**CITY OF ALBUQUERQUE
PLANNING DEPARTMENT
January 29, 2014
DRB Comments**

PROJECT # 1002523

RE: Lots 1A and 1B, Arias Acres

**CITY OF ALBUQUERQUE
PLANNING DEPARTMENT
Development Review Board
3/19/03 Comments**

**Sketch**  
**Hal Barnett**  
**Lots 1-A and 1-B**  
**Arias Acres**  
 Bernalillo County, New Mexico  
 March 2003

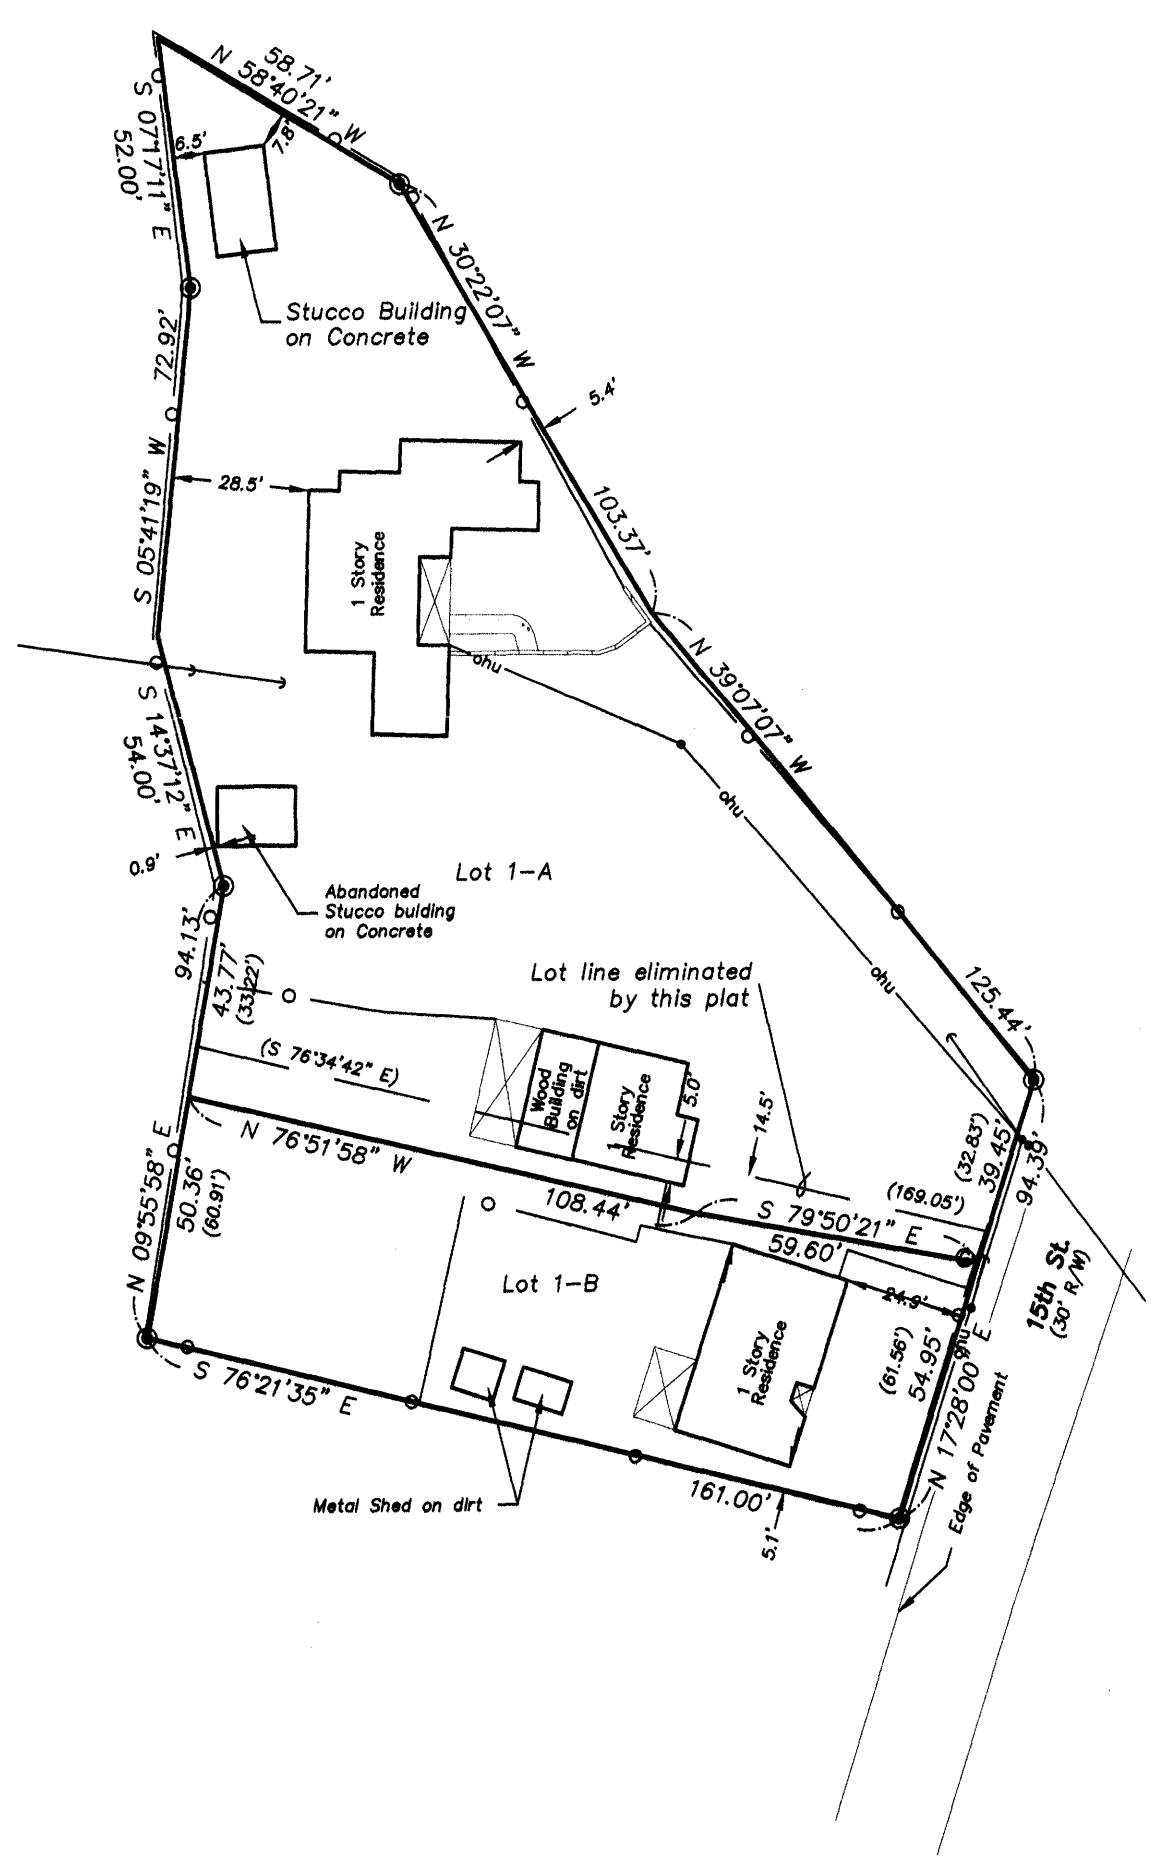
① It appears that there are 3 residences on 2 lots. Records show 2 water/sewer accounts under 1427 15th St. and none for 1500 15th. which is the correct address and how are all 3 houses connected?

② Need to show existing water meters and sanitary sewer manhole in street on survey sketch.

This property lies within the boundaries of the Sawmill/wells Park Sector Plan. The SR zoning designation is created in that plan. This zone allows two dwellings on lots 7,000 square feet and larger.

One of the existing houses does not have the required 15 foot front yard setback required in the RLT zone. (The SR zone is regulated by the RLT regulations in the City Zoning Code.) However, since this house exists and the proposed lot line change does not affect the lot line in the front of this house, the nonconformity will be allowed to continue under this platting action.

Site Sketch and  
Proposed Subdivision of  
Lot 1-A & 1-B  
Arias Acres  
City of Albuquerque  
Bernillo County, New Mexico  
May 2012

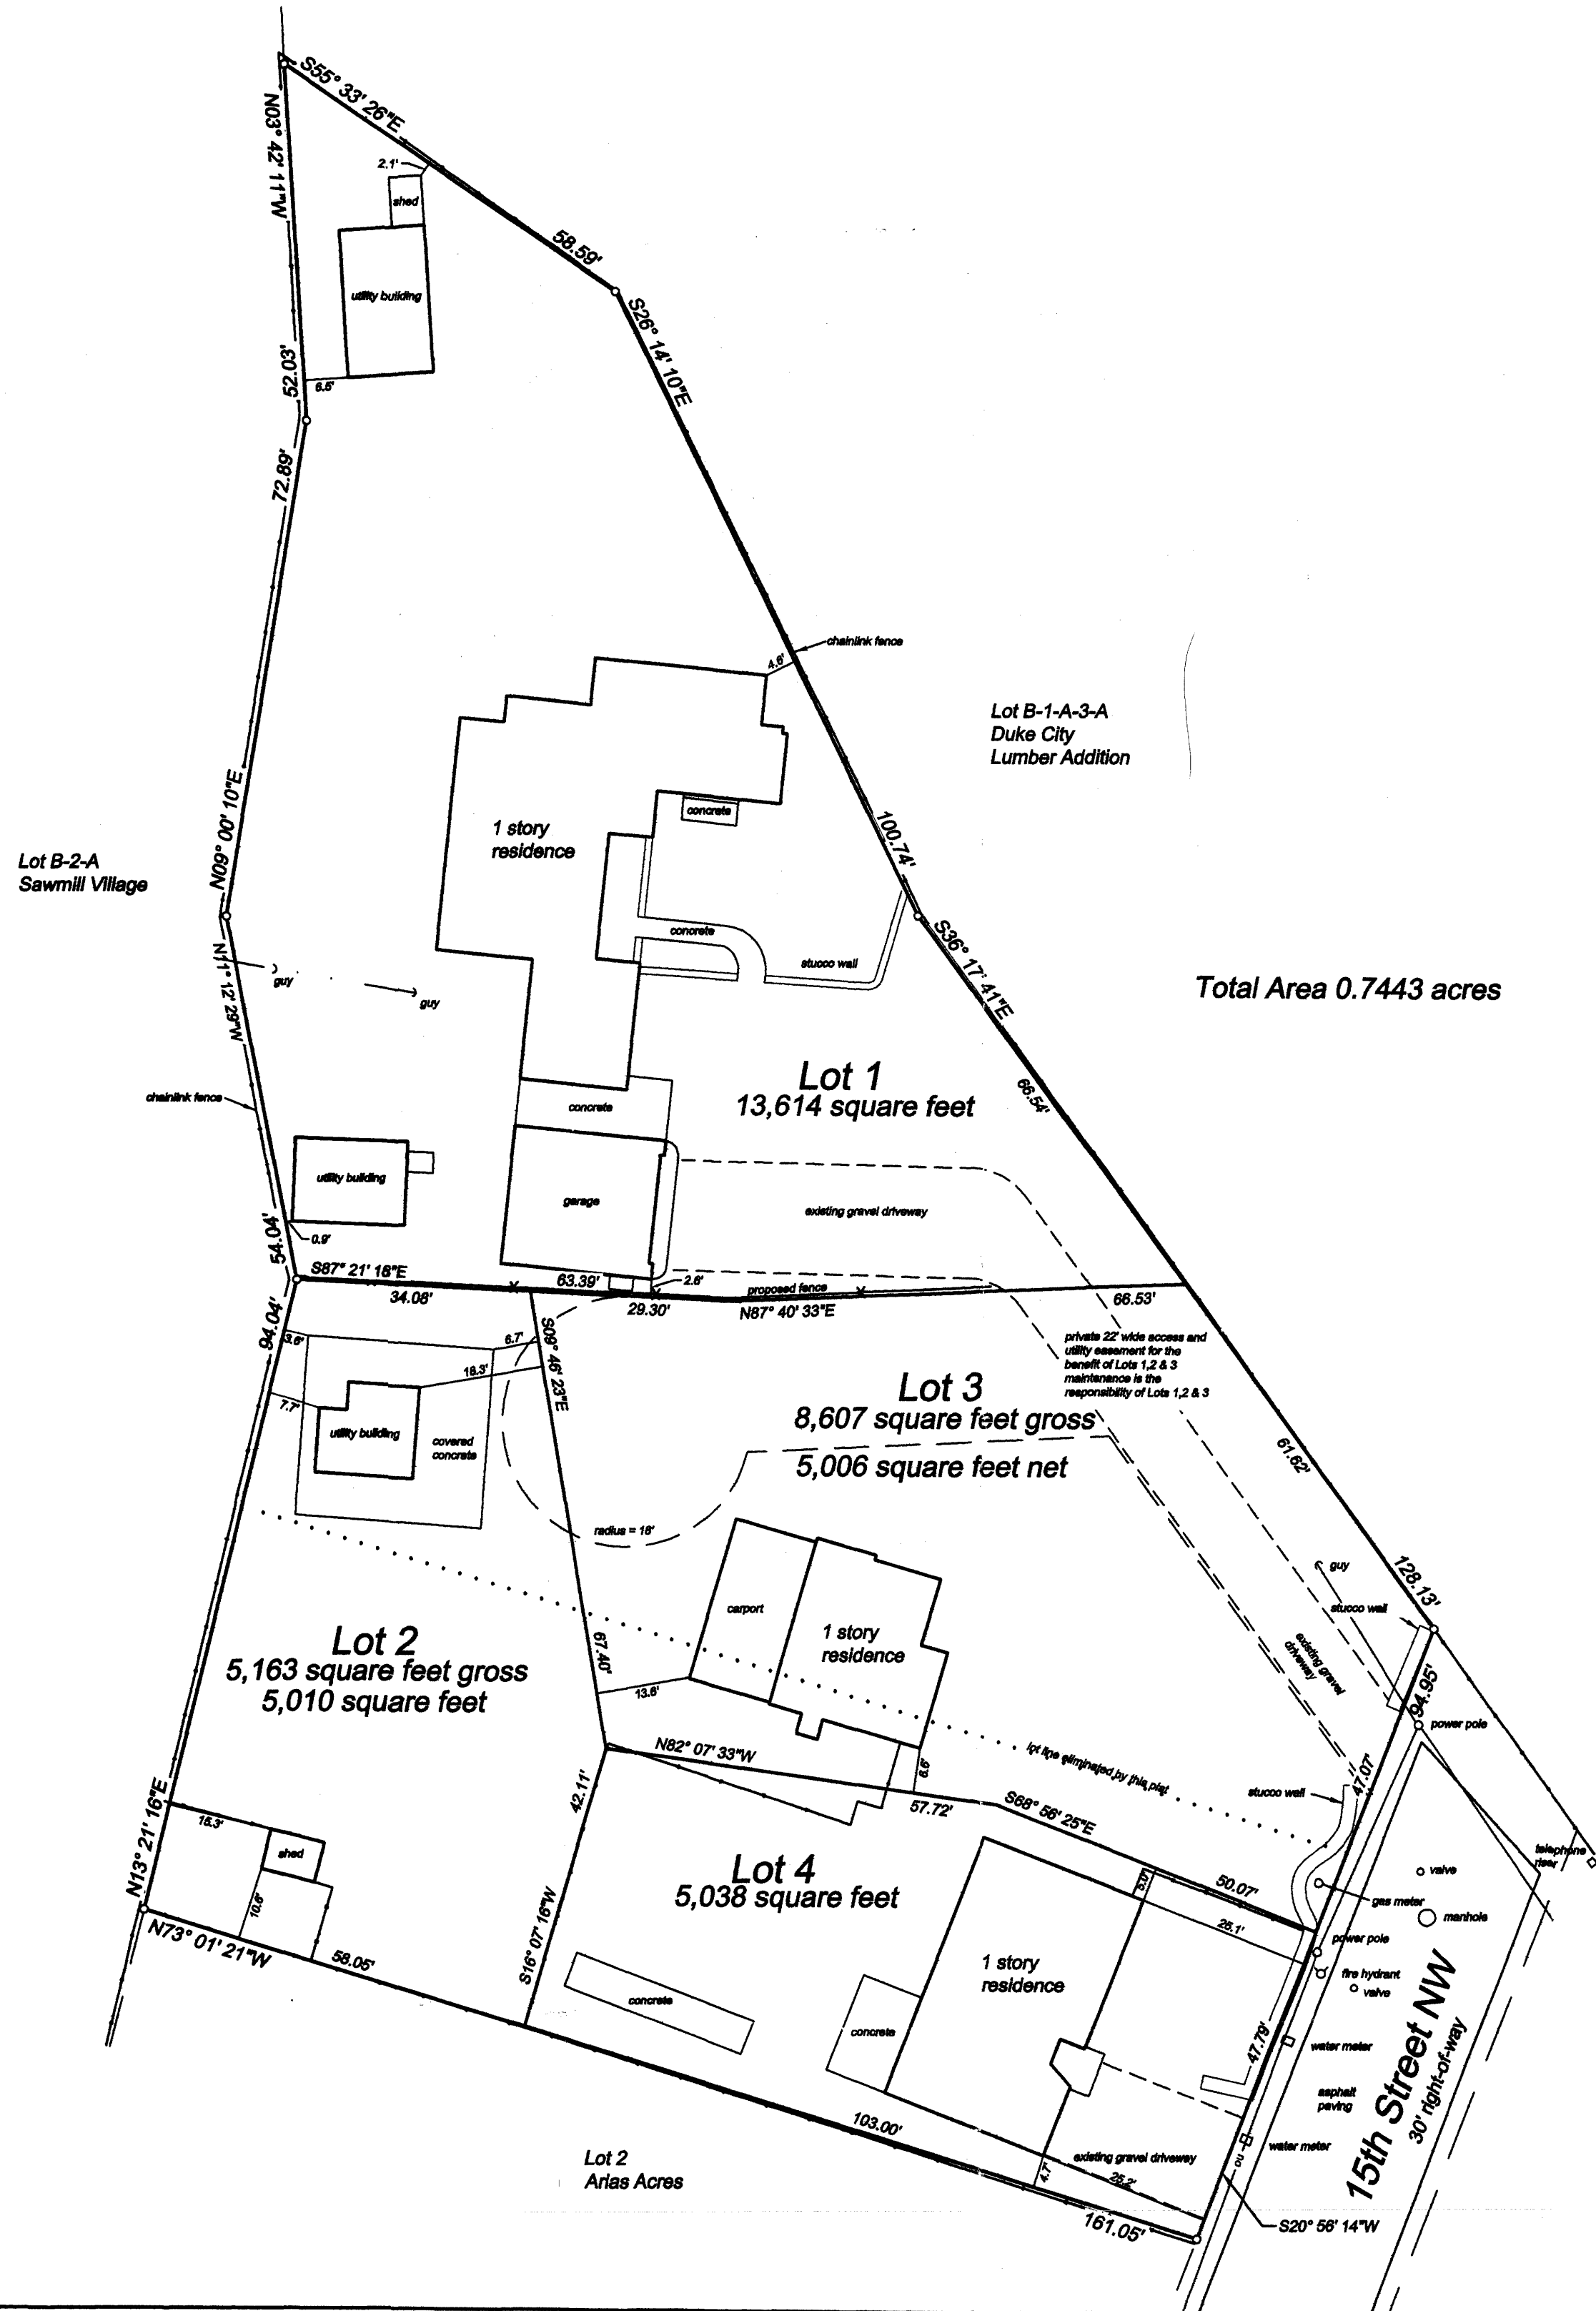
Accessory structures are not permitted on a lot without a primary structure (house) – the utility building and the shed on proposed Lot 2 would have to be removed prior to plat approval.

**PLAT OF**  
**LAND'S OF ANDREW MONIE**  
**LOT'S 1, 2, 3 & 4**  
 WITHIN  
 TOWN OF ALBUQUERQUE GRANT  
 PROJECTED SECTION 18, TOWNSHIP 10 N., RANGE 3 E.  
 BERNALILLO COUNTY, NEW MEXICO  
 JANUARY 2015  
 SHEET 2 OF 2

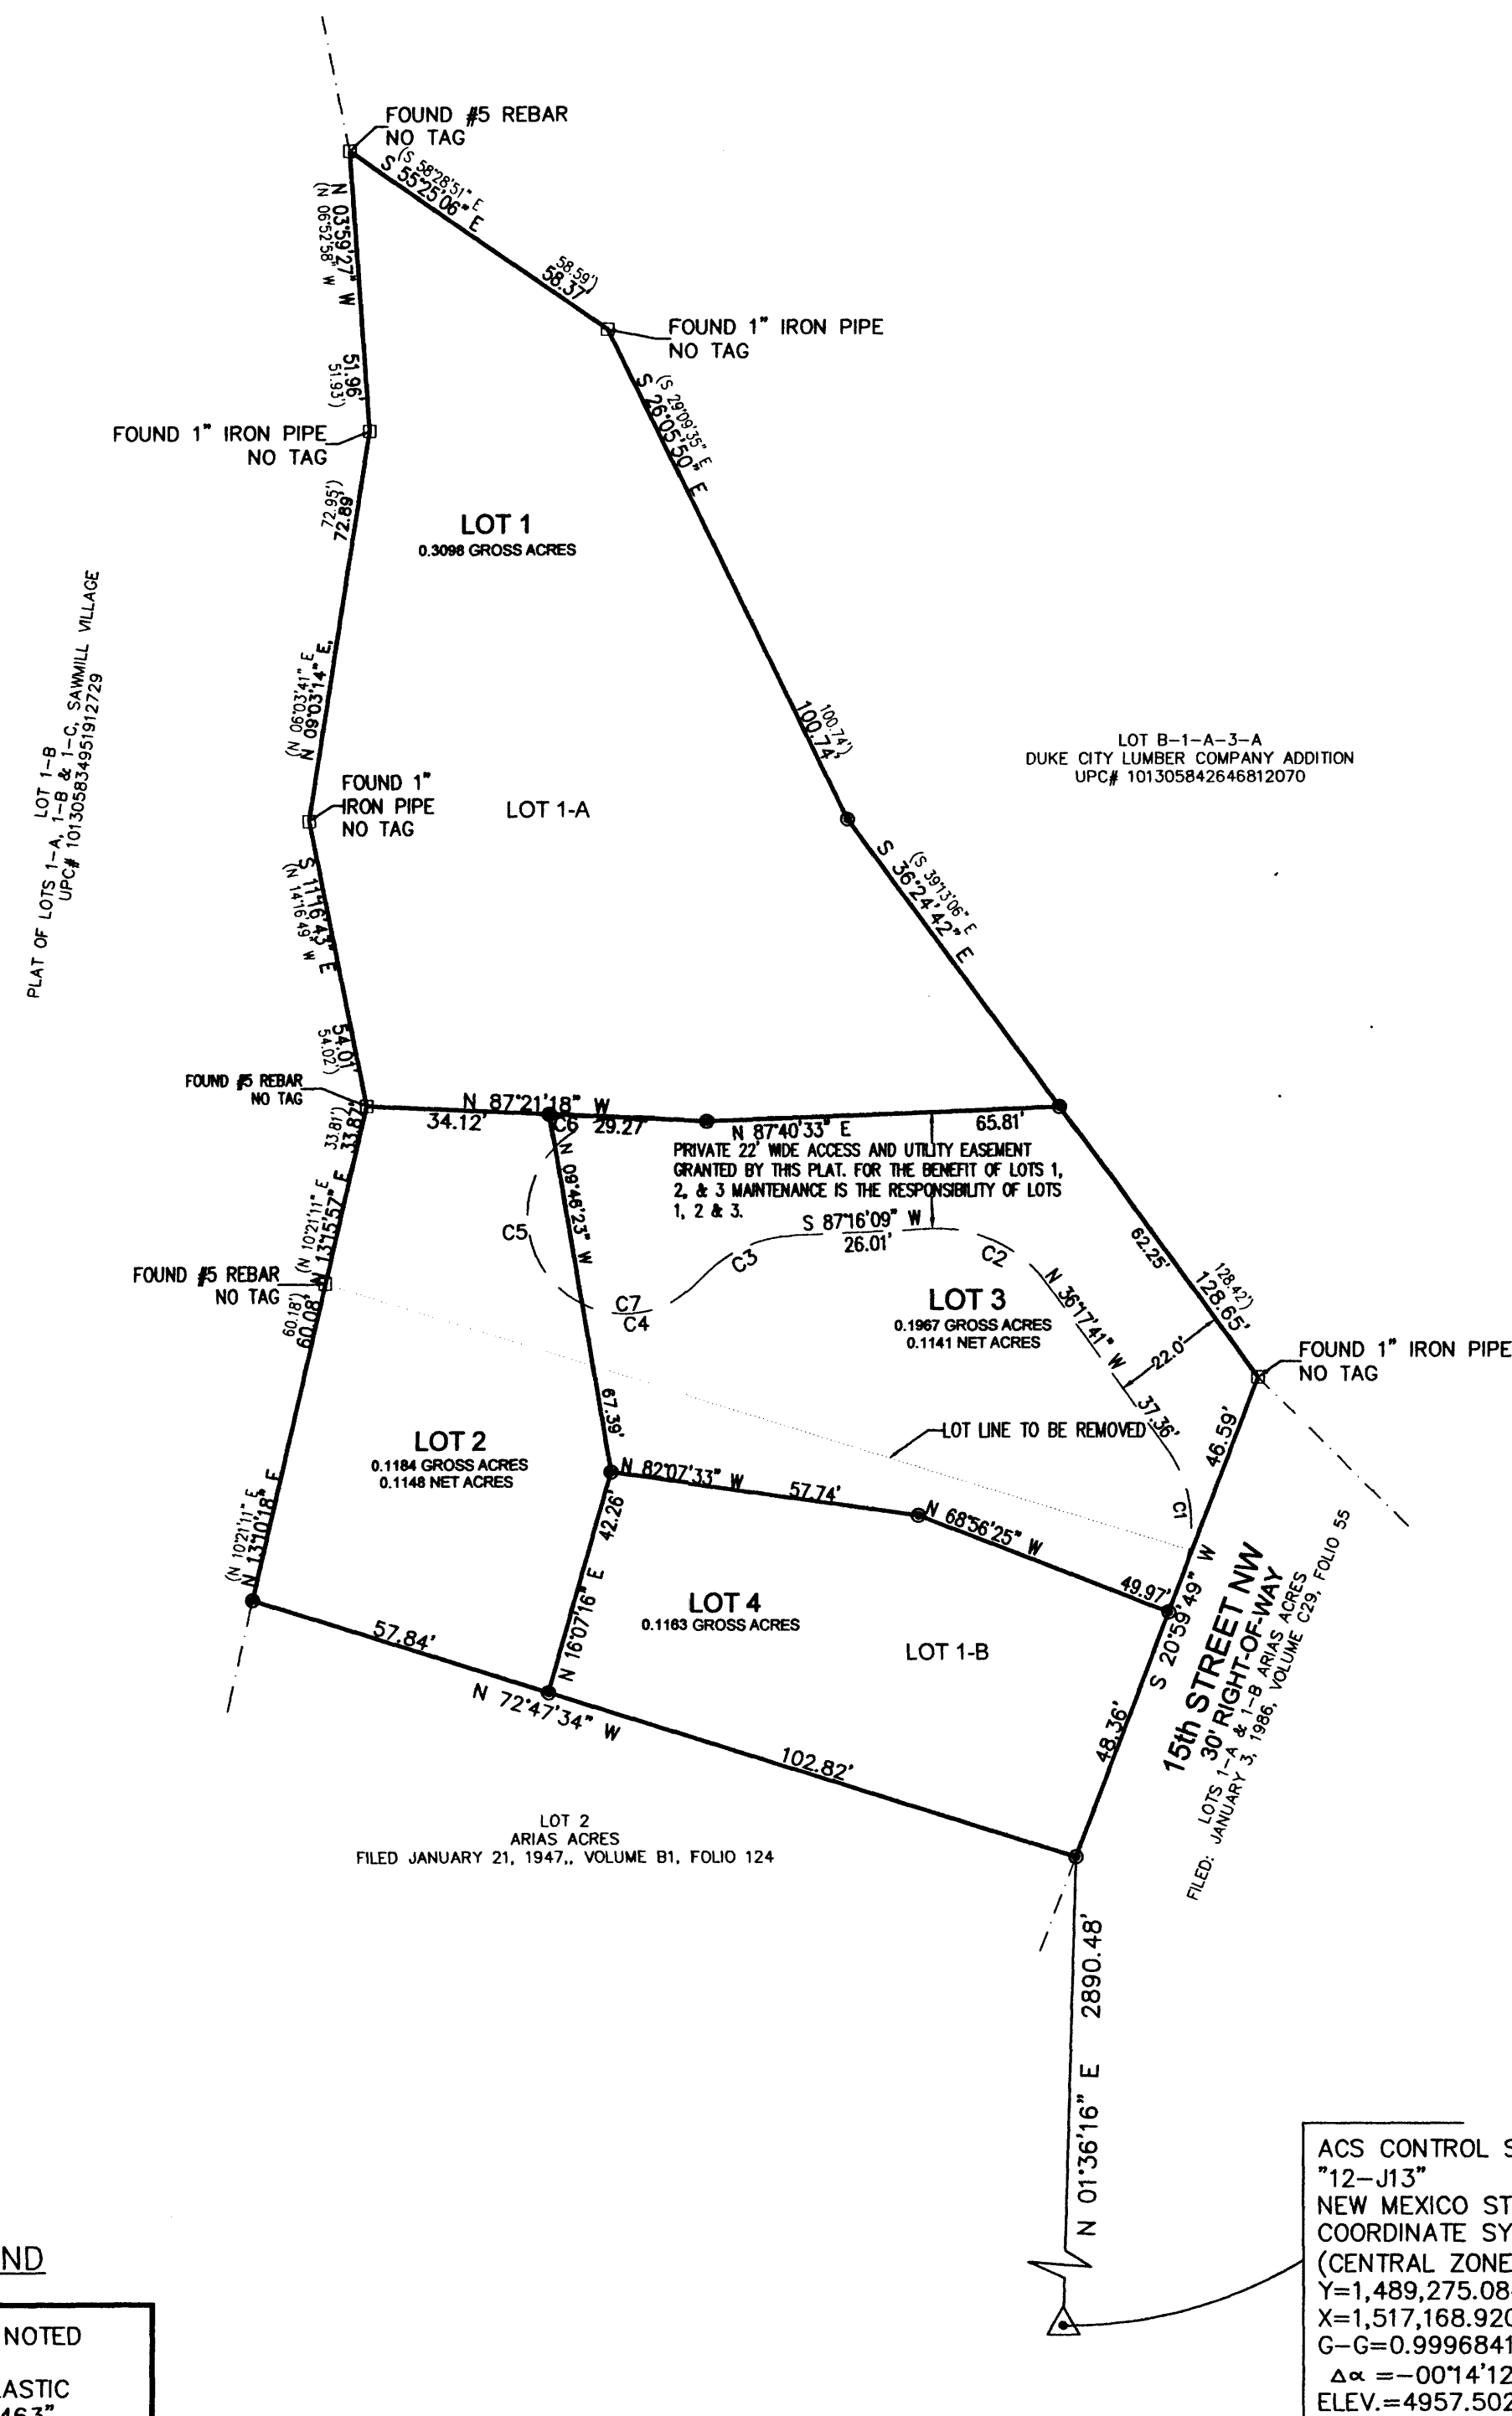
Please provide a copy of any ZHE decision or correspondence regarding conversion of Accessory Structure to a primary structure/house.

There is a pending plat which will construct a turnaround for 15th Street – if this current request would wait for that plat to be filed then the proposed turnaround on this site may not be required; refer to comments from Transportation Development.
